Our ref: WA/2019/127046/01-L02
Your ref: 19/01740/HYBRID
Date: 14 November 2019

Outline planning permission (all matters reserved except for access) for up to 23,400sq.m of B1 development (Use Classes B1a and/or B1b and/or B1c); highway works (including provision of a new roundabout at the junction between Vendee Drive and Wendlebury Road); creation of a wetland and landscaped areas; and associated infrastructure works. - Full planning permission for a health and racquets club, associated access and car parking, outdoor tennis courts, air dome, outdoor swimming pool, spa garden and terrace, and associated landscaping

Land Adj To Promised Land Farm, Wendlebury Road, Chesterton

Environment Agency position

Figure 7: Preliminary Flood Compensation Scheme 1 (Drawing No. S1358-Ext-35A)

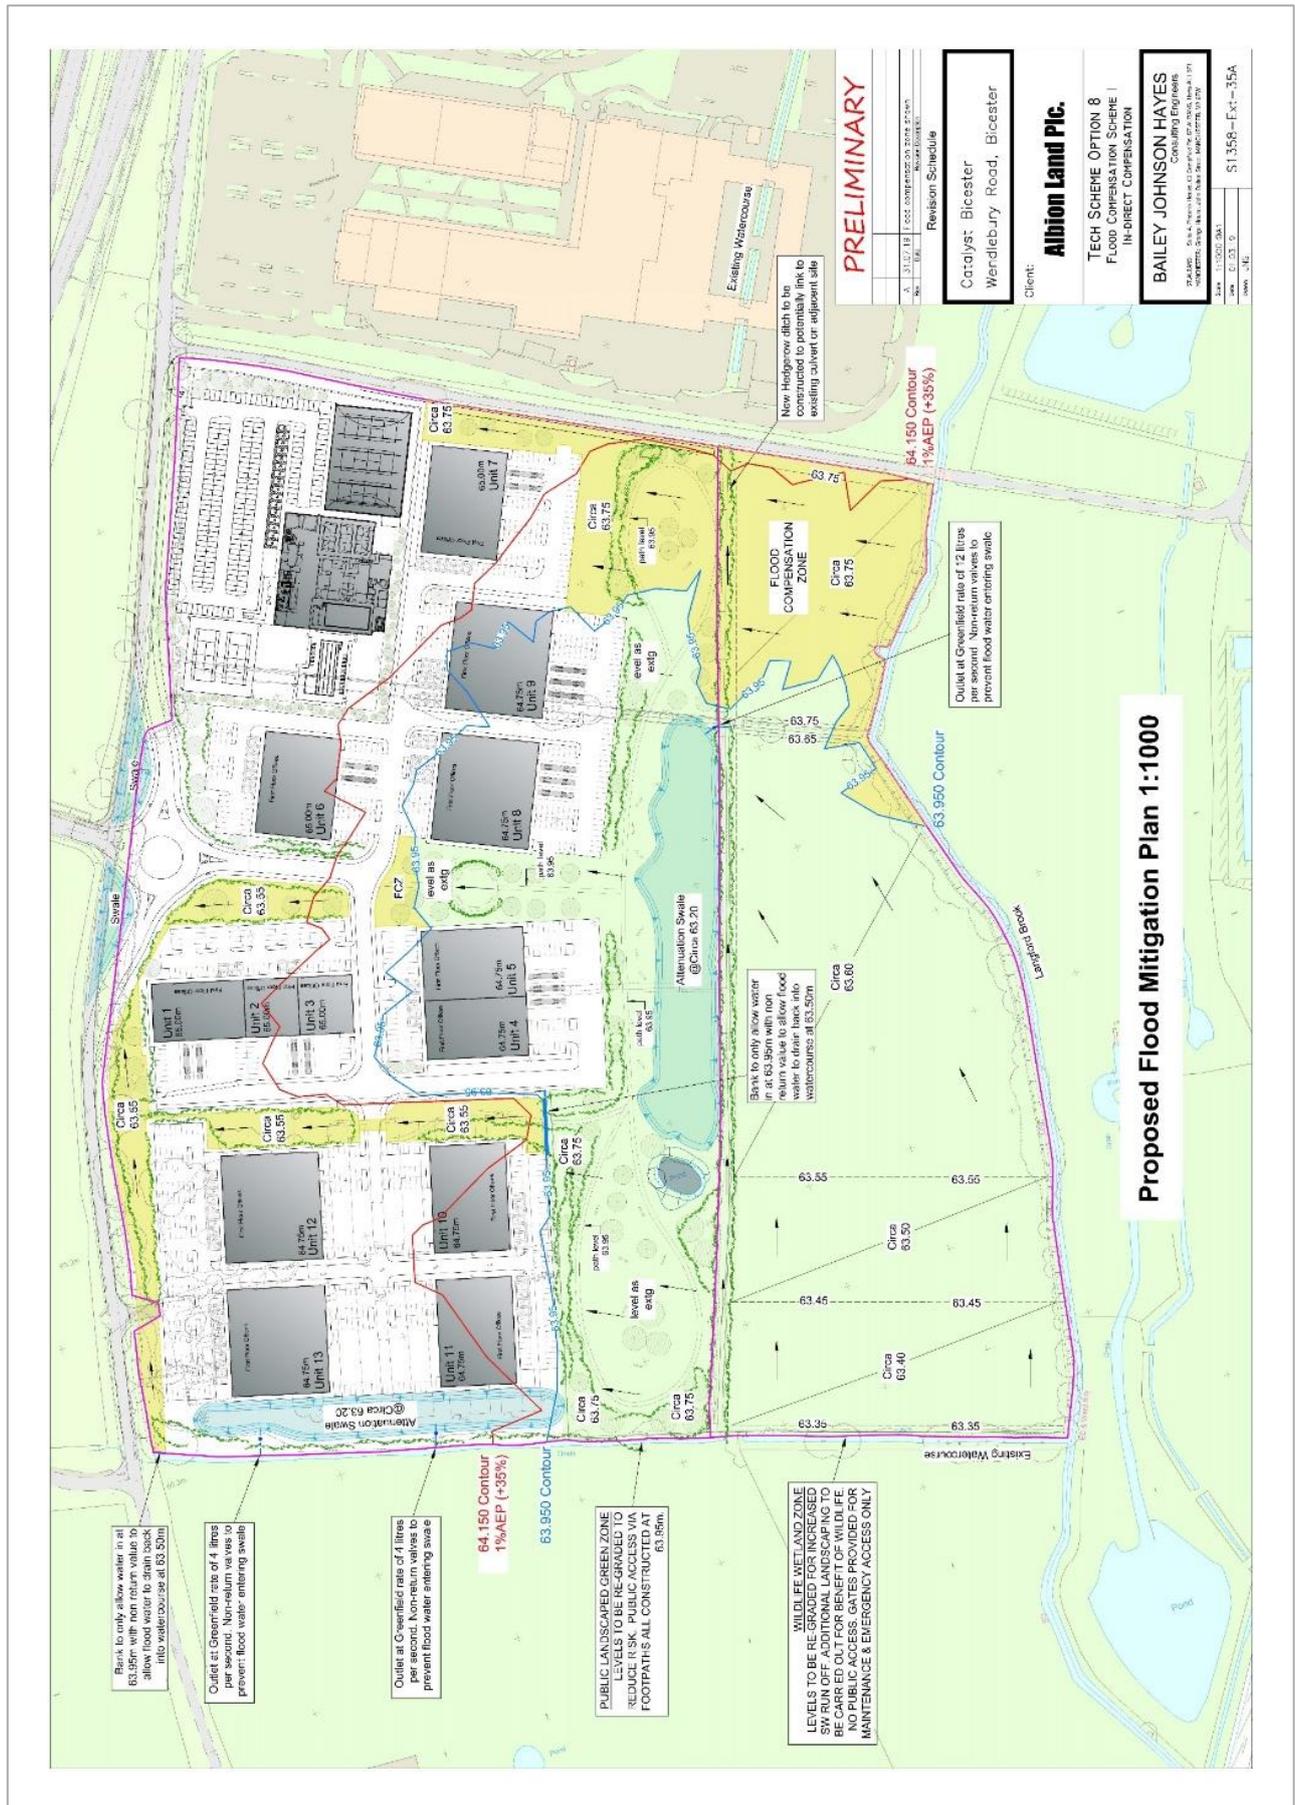
There is no detail in the FRA in respect of how much compensation is necessary for the loss of floodplain storage and how this can be incorporated into the site. We expect flood compensation to be provided on a level for level basis up to the 1 in 100 plus 35% flood level. This detail is something we are unable to condition as we need to know that level for level compensation is achievable before outline permission is granted.
